Department of Planning, Housing and Infrastructure

Re: Objection to Emirates Wolgan Valley Resort – Modification 4
Project Number: MP06_0310 Mod 4

Figure 3. Preferred flight paths.

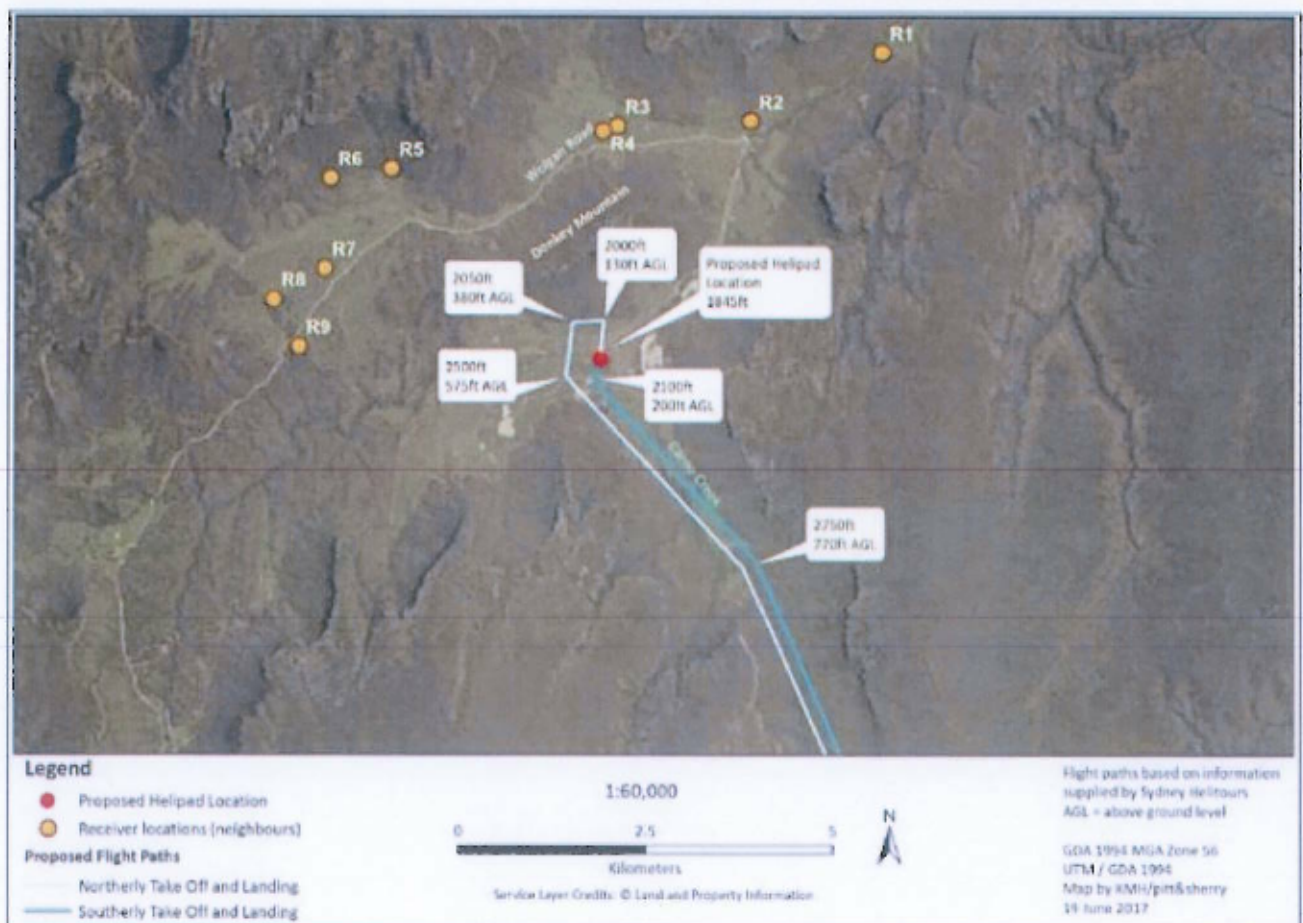
Equally concerning is the proposed alteration to the approved flight path. The originally approved route largely avoided direct impacts on surrounding private properties. The newly proposed route, shifting from the south-east via Carne Creek to an approach from the south-west, has the potential to directly impact a large number of permanently inhabited rural properties throughout the south-western section of the valley.

I am also concerned that the documentation accompanying the modification application lacks sufficient clarity regarding the precise flight path alignment, operating altitudes, and projected noise impacts at individual properties. This lack of detail makes it difficult for affected residents and landholders to properly assess the full extent and consequences of the proposal.

Figure 2- It is particularly alarming to see that the proposed flight path passes within 1300m from the Wolgan Falls Canyon. An area of the national park widely recognised for its exceptional beauty, tranquillity, and environmental sensitivity.
